THE VILLAS AT CLAREMONT RANCH

PUD DEVELOPMENT PLAN & PRELIMINARY PLAN

PUD & PRELIMINARY PLAN

DATE: 9/17/21 BY: JS DESCRIPTION: County Comments

## PUD DEVELOPMENT PLAN & PRELIMINARY PLAN

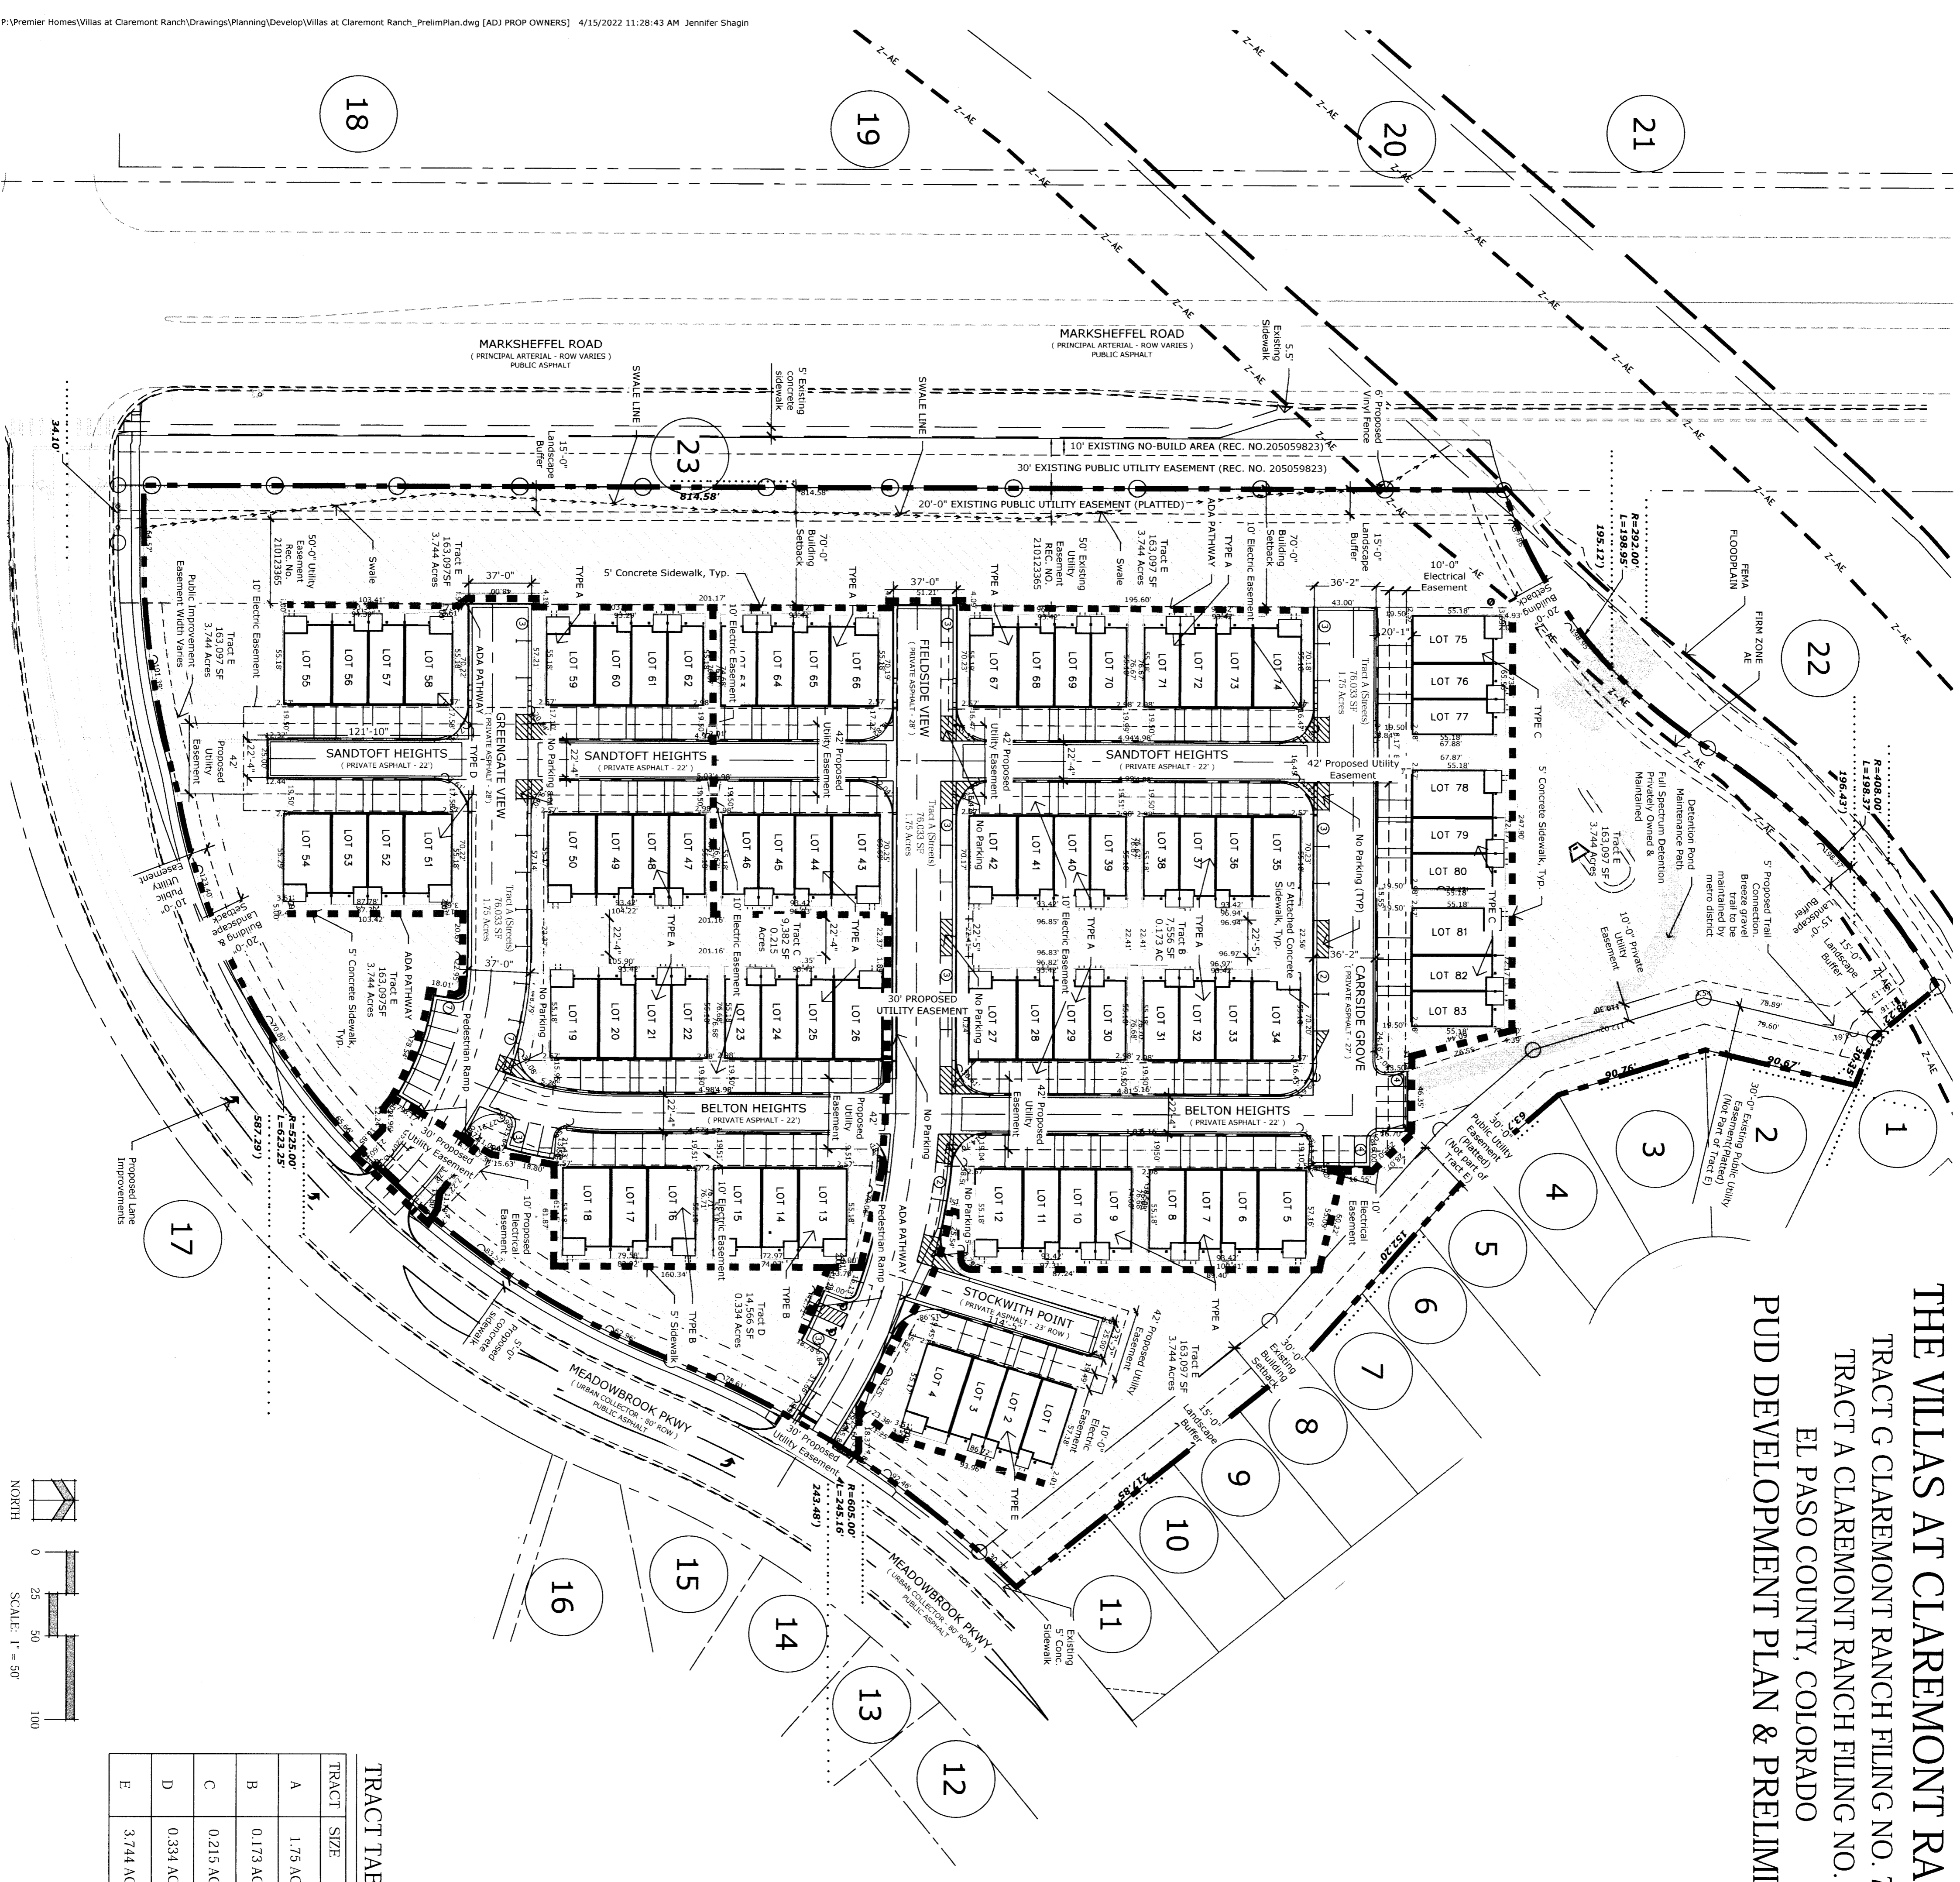
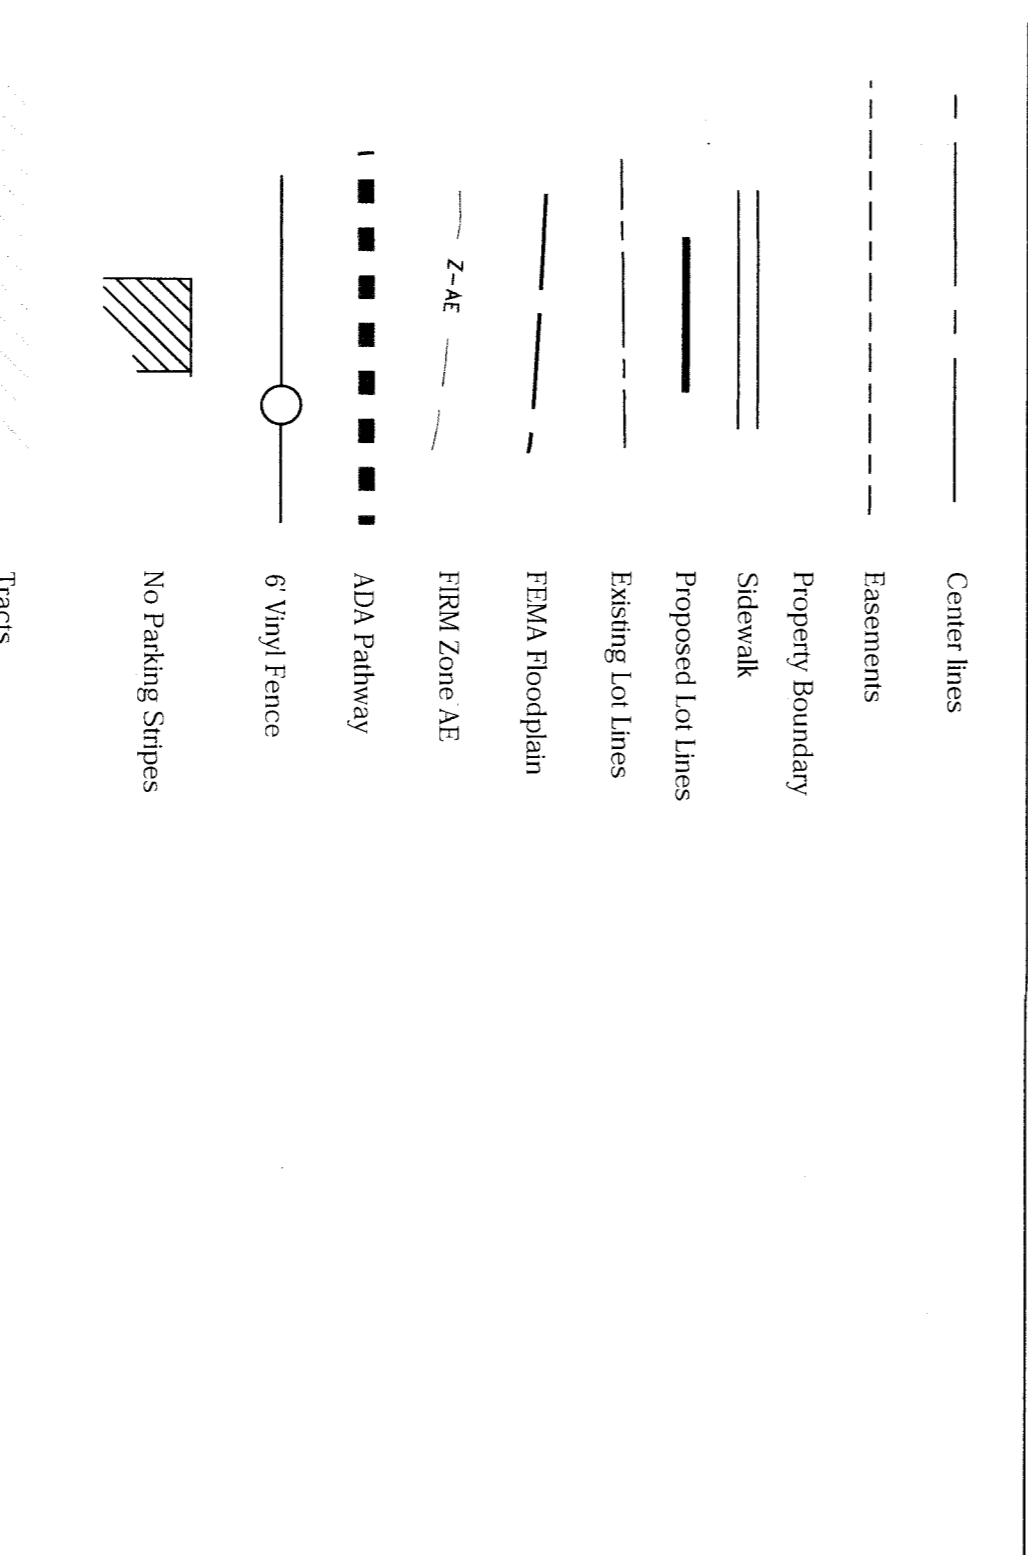
Previous comment not addressed: please provide a legend for line type and hatch type

It appears that this will be divided into two phases. However, there is no indication of any phased development in any documentation provided. Please revise accordingly. If proposed phased development, include in letter of intent per comments from first review.

Per previous comment: property boundary line bearings and distances and dimensions have not been provided

LOT TYPICALS & DIMENSIONS

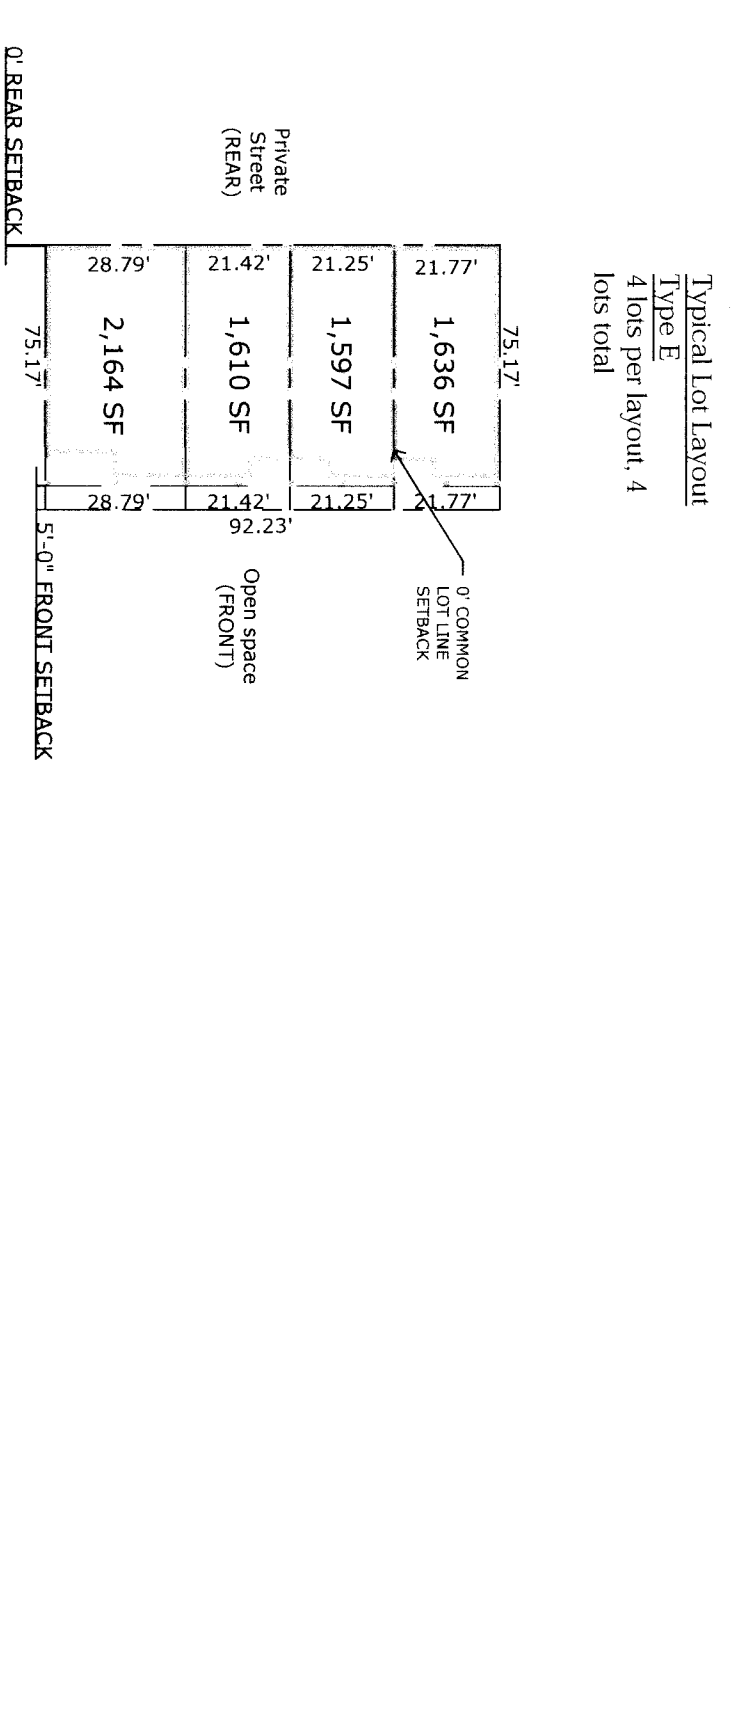
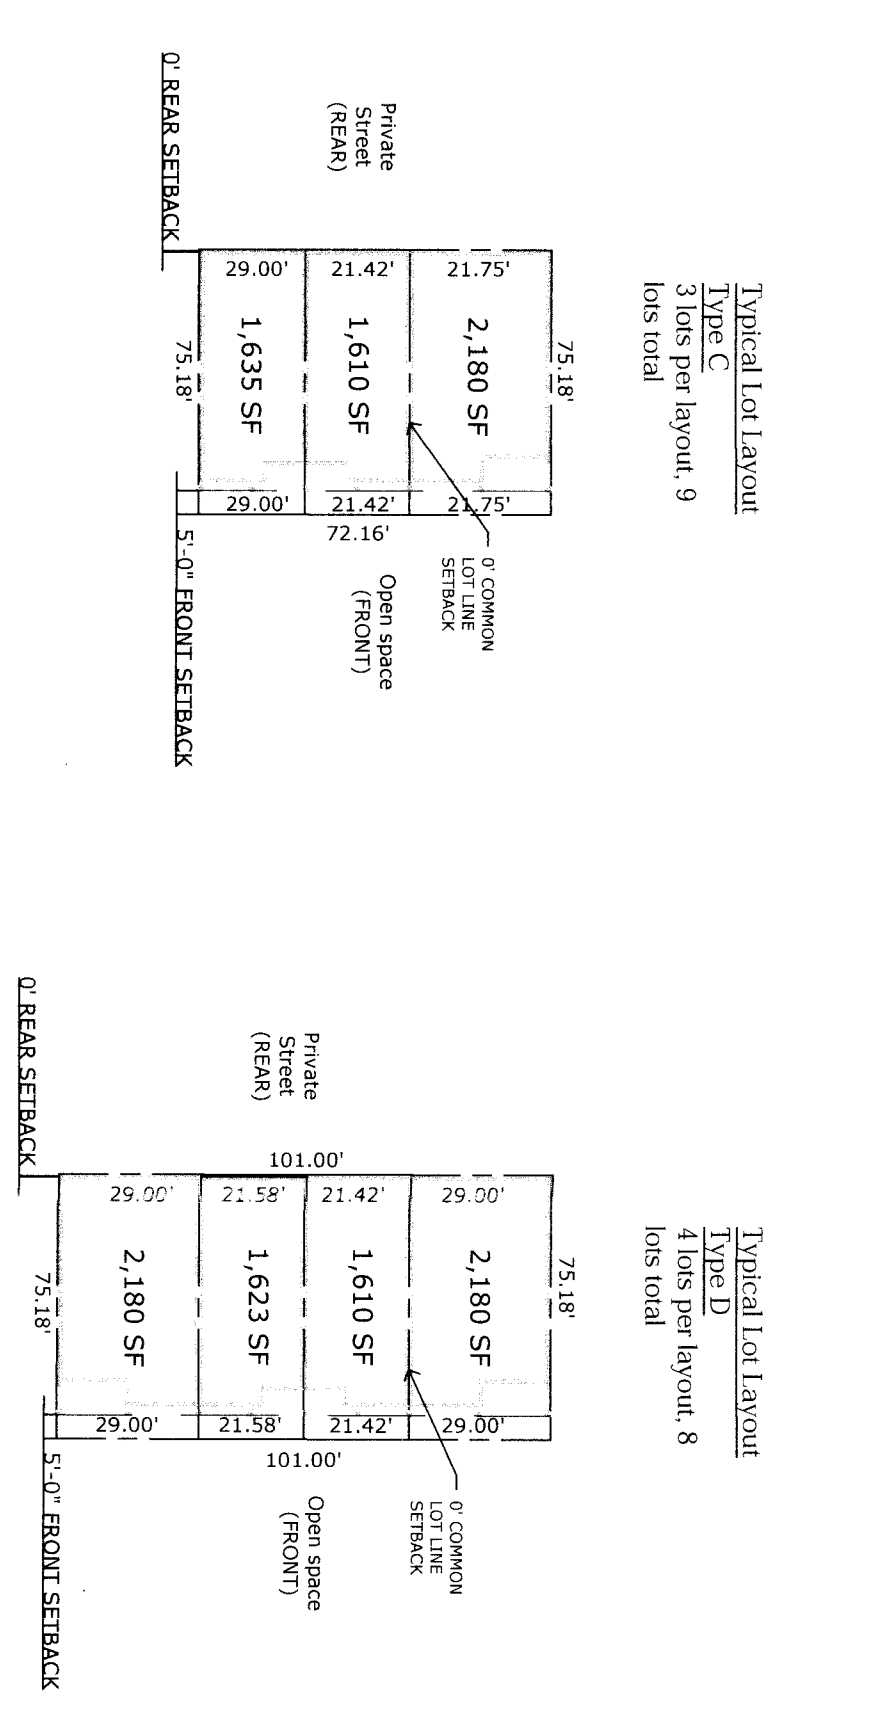
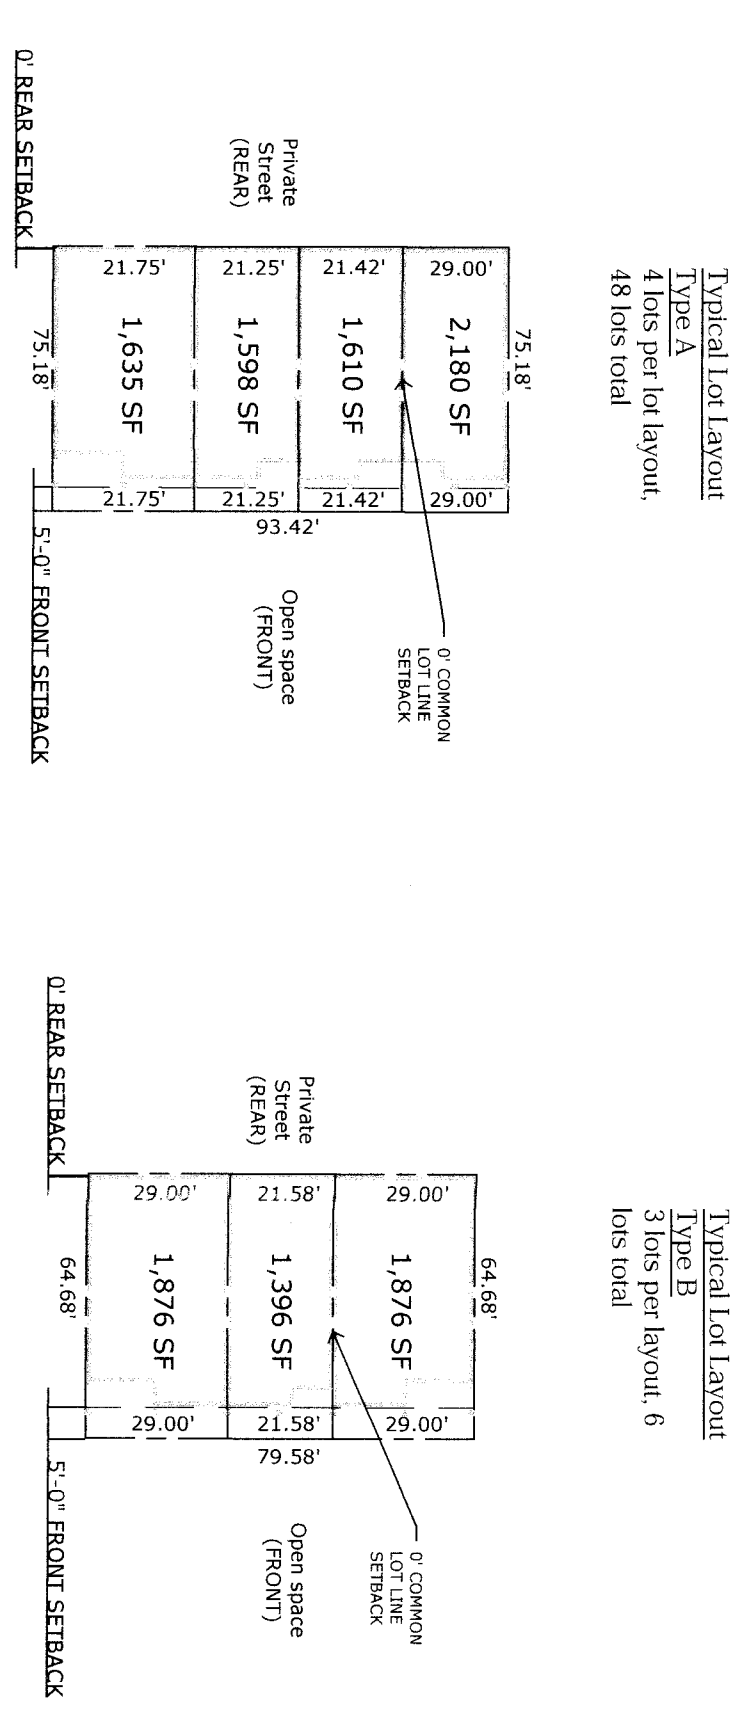
Why is the line type different on Type B lots? Does this signify something?
